# CITY OF ALBUQUERQUE

**Re: Lead Avenue Townhomes  
Grading and Drainage Plan  
Engineer's Date 11-6-14 (K15D094)**

Based upon the information provided in your submittal received 11-6-14, the above referenced plan is not approved for Building Permit. Please address the following comments:

FIRM #35001C0353H
NOT TO SCALE

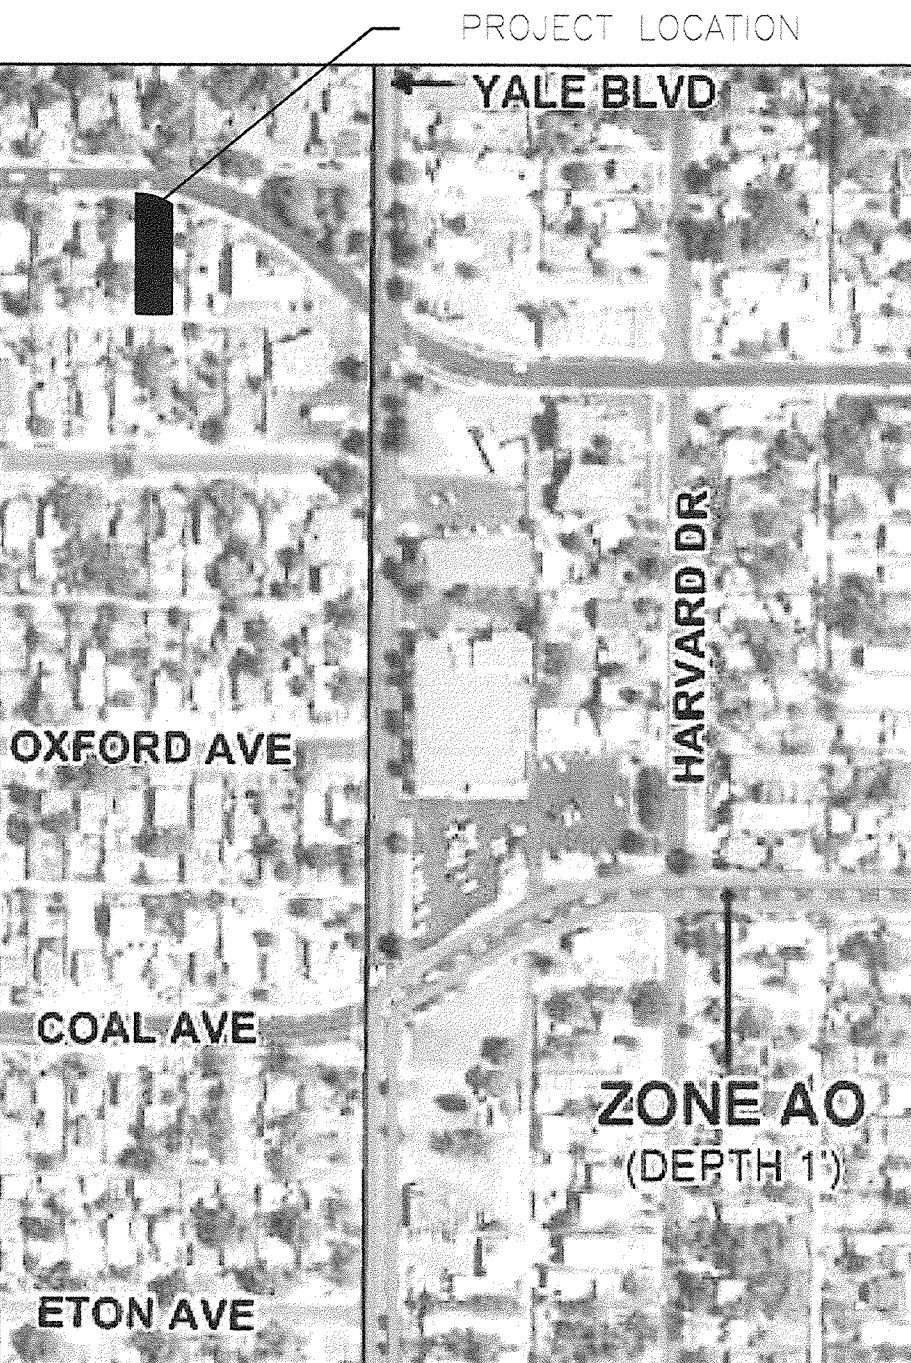
1. Always include a FIRM Map or narrative of the 100 year Flood Plain. Reference the vicinity map the site is shown on.
2. Many items are lacking for the drainage analysis:

DRAINAGE BASINS
NOT TO SCALE

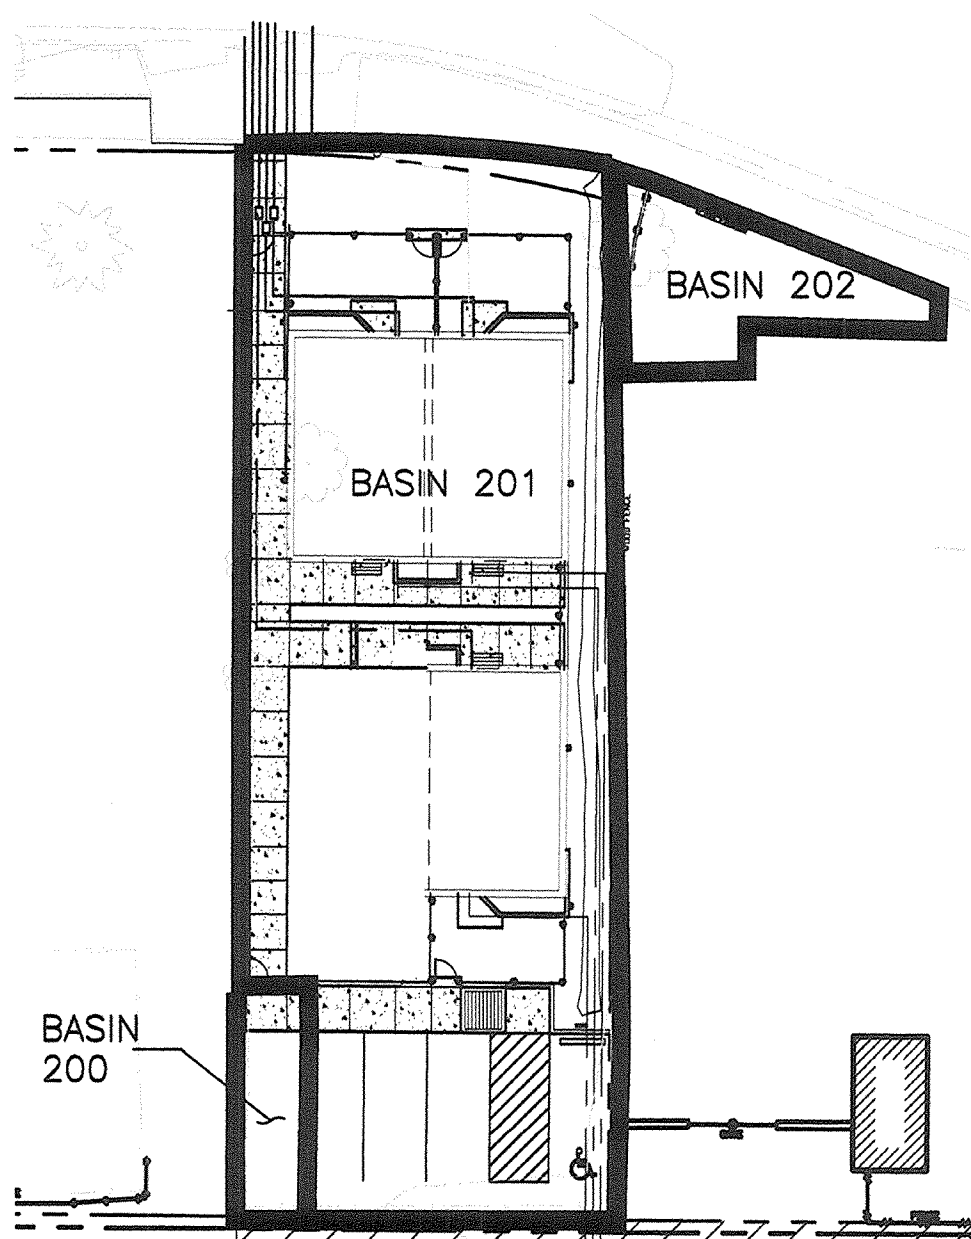
- A. Per Table A-2, the precipitation for this site is 2.35 inches not 2.2 inches.
  - B. The Existing Conditions Table shows two basin 101s. Revise one of them and show them on the plan. A small image of those basins is sufficient.

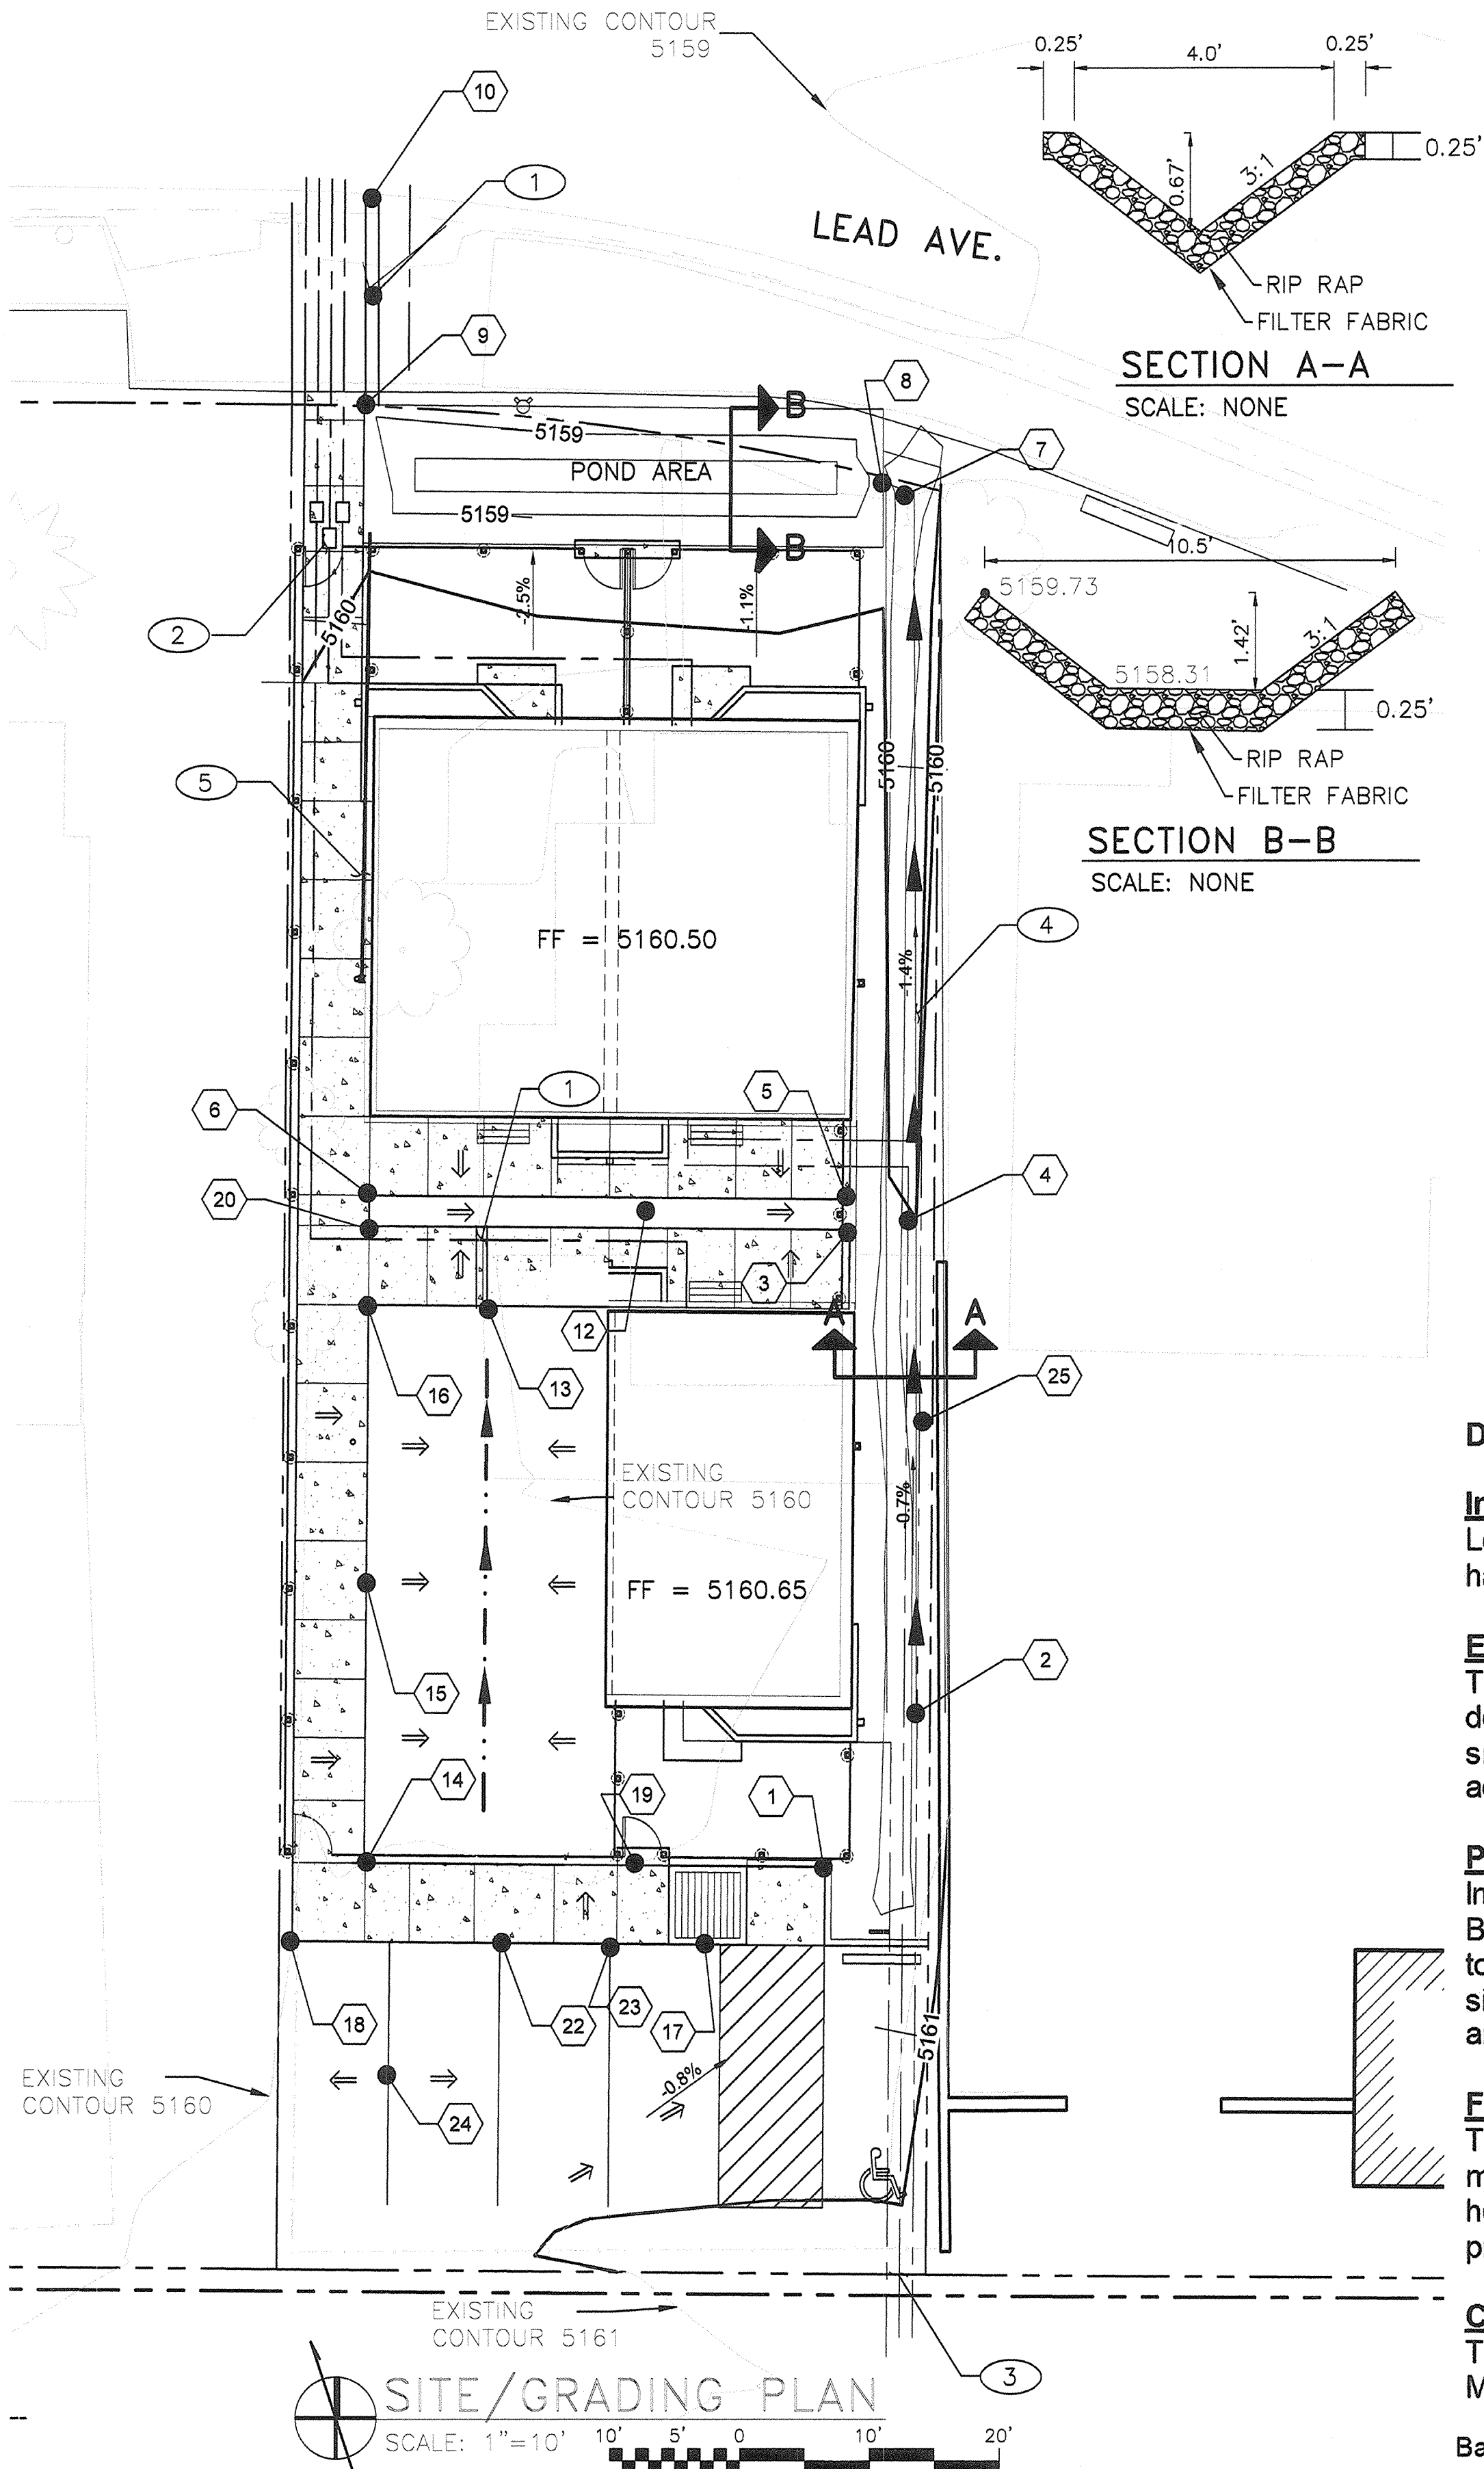
- C. There is off-site flow coming onto the property. Determine the size of the area, the flow amount, and how it will be passed through the site.
  - D. Identify the areas of all existing and proposed land treatment per Table A-4 of the DPM. Determine flow volumes based on weighted E calculated from the E for each land treatment from Table A-8 of the DPM. Calculate flows based on peak discharge amounts for each land treatment area from Table A-9. Detain the difference between existing and proposed flows.

- E. The First Flush was not discussed. Per the City Drainage ordinance, the 90<sup>th</sup> Percentile Storm Event, which is 44 inches, is to be managed. Reduce 0.44 inch by the 0.1 inch for the initial impervious abstraction in Table A-6 of Section 22 of the DPM. Multiply the remaining 0.34 inch by your impervious area. This is the amount of the First Flush necessary for the site. Show that amount on your plans. State the ponding volume that is being provided for the First Flush. Utilize landscaping areas for the ponding.

- F. Provide calculations for sizing your swale and discharge pipes. What is the slope of the swale? Call out rip-rap instead of gravel and provide a size.

- G. Include labels for all existing and proposed contours.
  - H. Provide spot elevations throughout the site including ADA ramps and spaces, door locations, roof drain outlets, inverts for the swale and the outlet to Lead Avenue, and other critical points.

3. If the alley, which is City Right-of-Way, is being paved, construction plans will need to be submitted for Work Order. Call out standard City details for alley sections and pavement. The work for the drainage lines (and removal and replacement of City sidewalk) should be included in those plans also. If the paving

of the alley is eliminated from the project, the drainage lines can be done by S0-19. Include standard S0-19 language and signature block on the plans and specify an S0-19 review on the DTIS.
